CITY OF ALBUQUERQUE

Re: Rite Con Office
519 Oliver Ross Dr. NW
Traffic Circulation Layout
Engineer's/Architect's Stamp **11-02-2015** (K09D042)

Based upon the information provided in your submittal received 11-27-2018, the above referenced plan cannot be approved for Building Permit until the following comments are addressed:

DRAWING TITLE: **SITE PLAN**

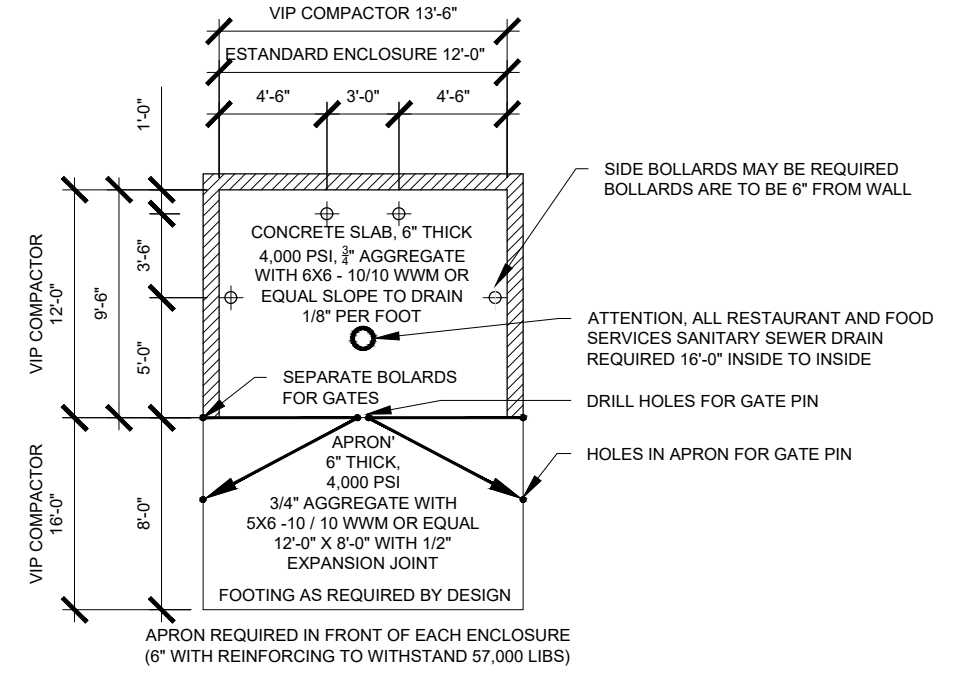
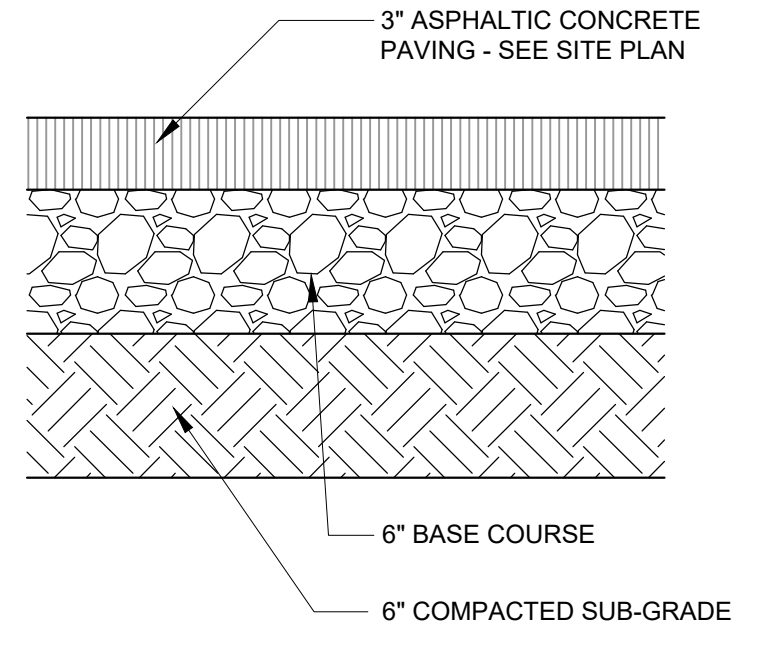
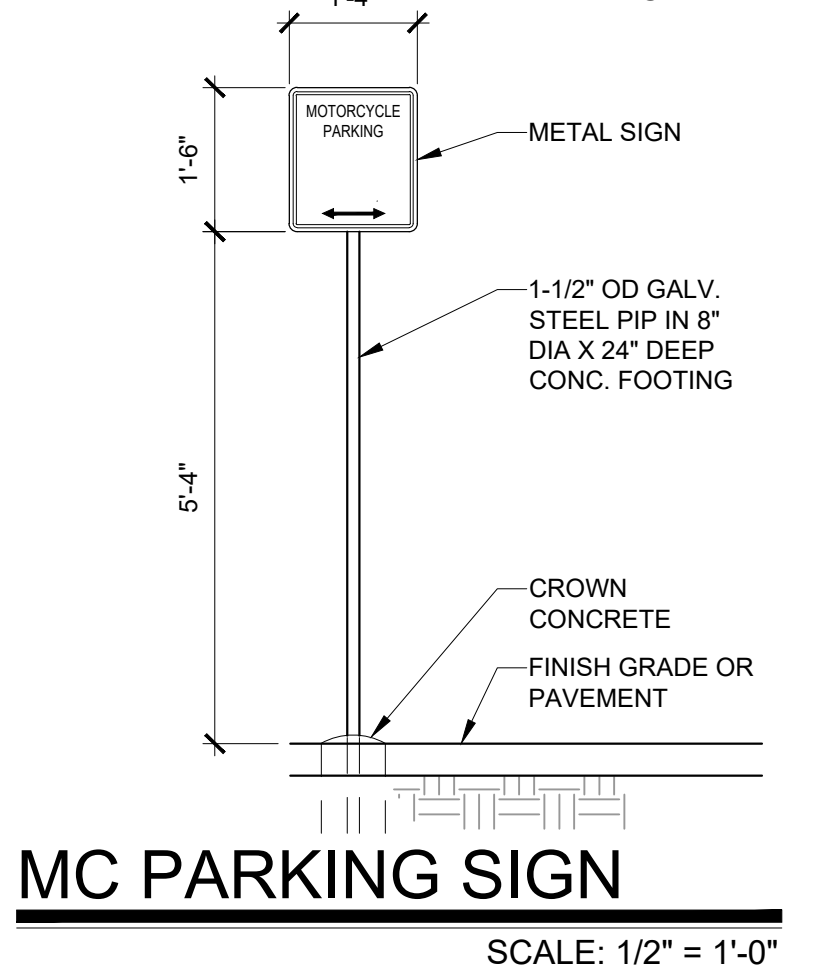
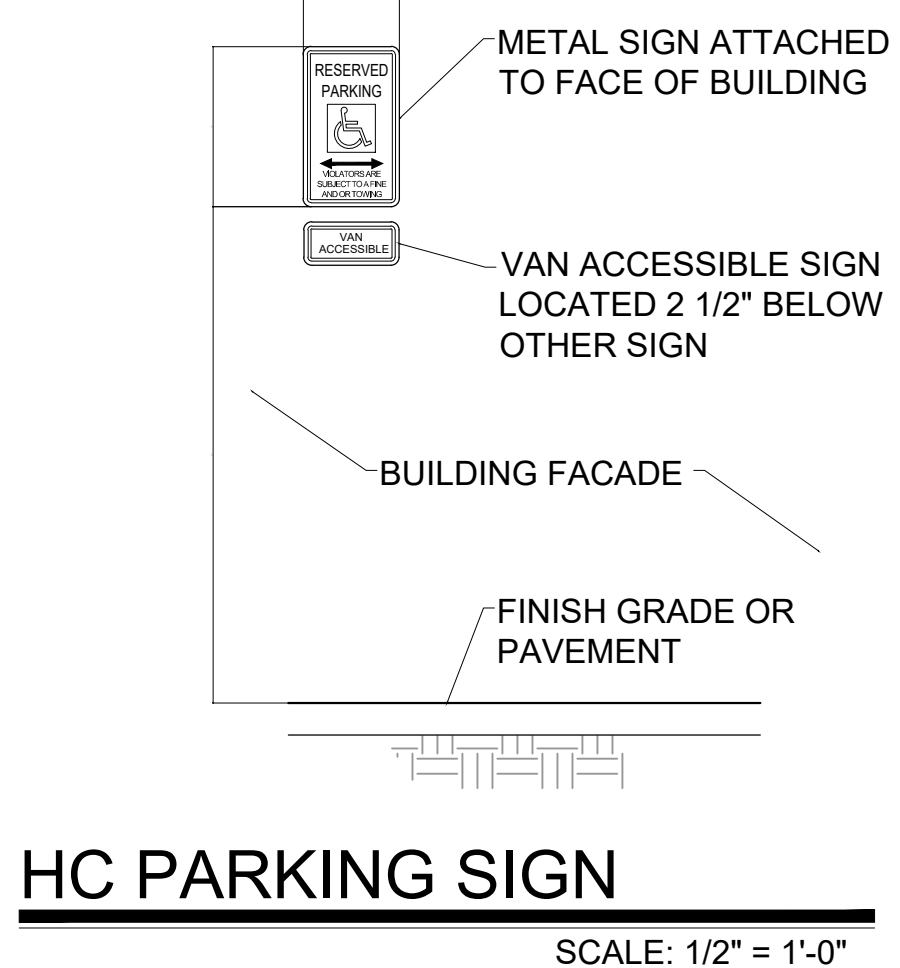
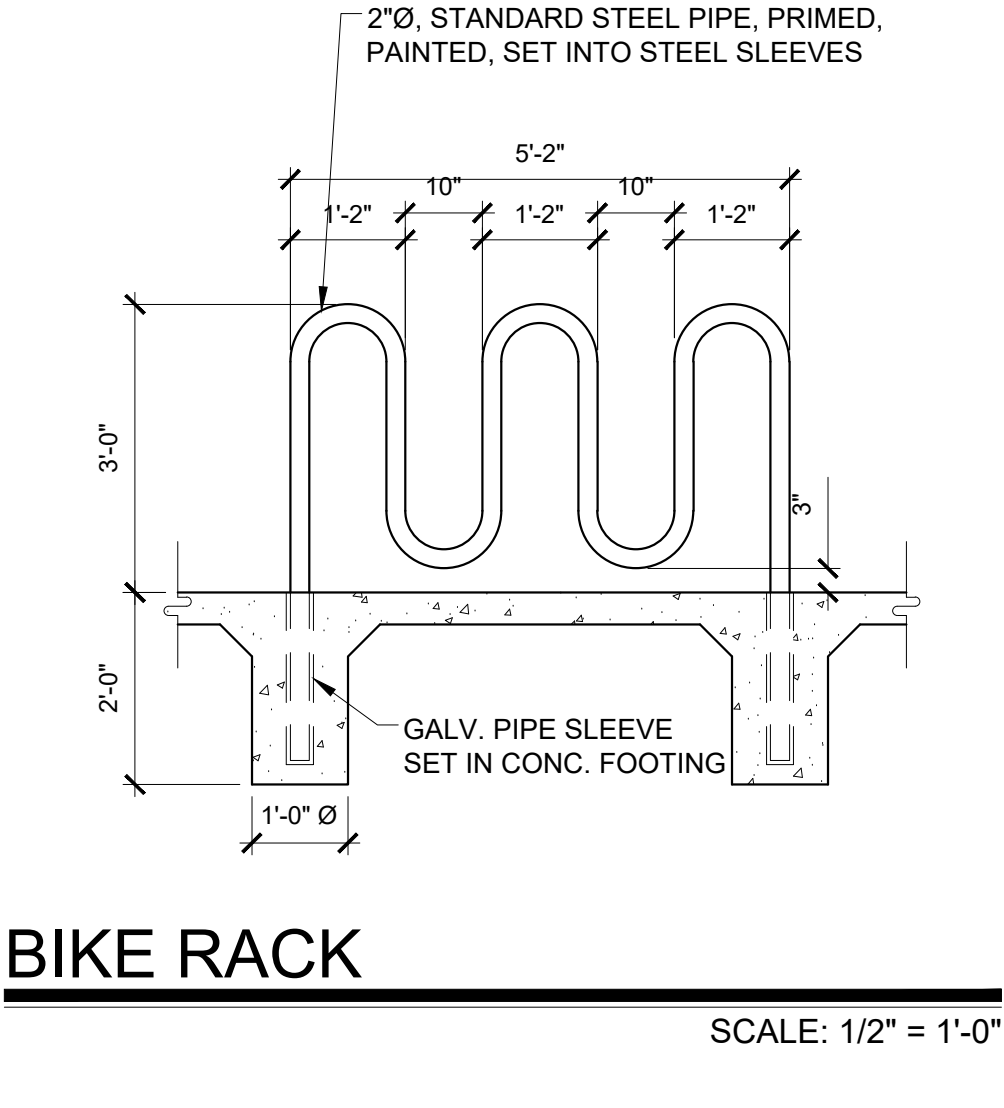
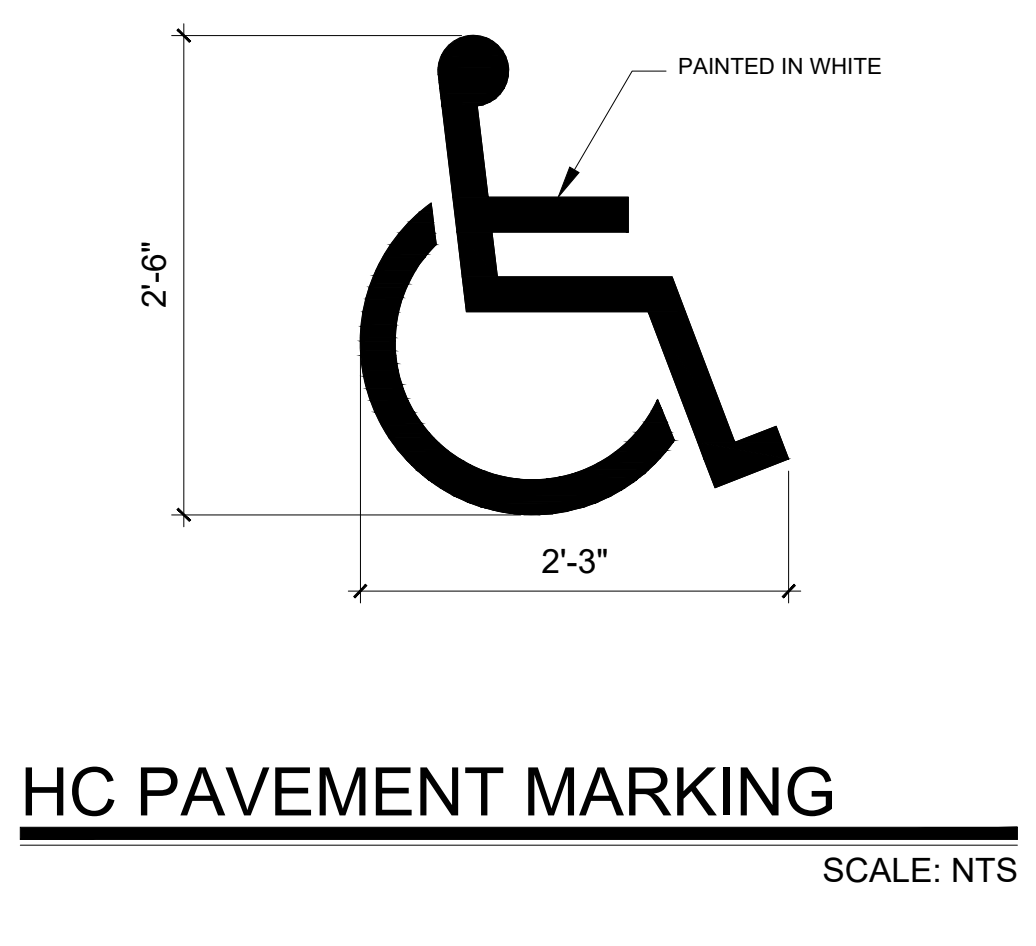
1. The handicap accessible spaces must be a minimum of 8.5 ft. in width. The dimension is not shown on the plan.
2. ADA curb ramps must be updated to current standards and have truncated domes installed.
3. Show the clear sight triangle and add the following note to the plan: "Landscaping and signage will not interfere with clear sight requirements. Therefore, signs, walls, trees, and shrubbery between 3 and 8 feet tall (as measured from the gutter pan) will not be acceptable in the clear sight triangle.
4. Please consider decreasing the width of the curb cut (access) to 25'.
5. Remove striping off of the motorcycle parking space.
6. Bicycle rack should be placed near the front entrance of the building. Please indicate where the entrance is.
7. Please show a section view of the asphalt pavement along with details regarding the material and the width.
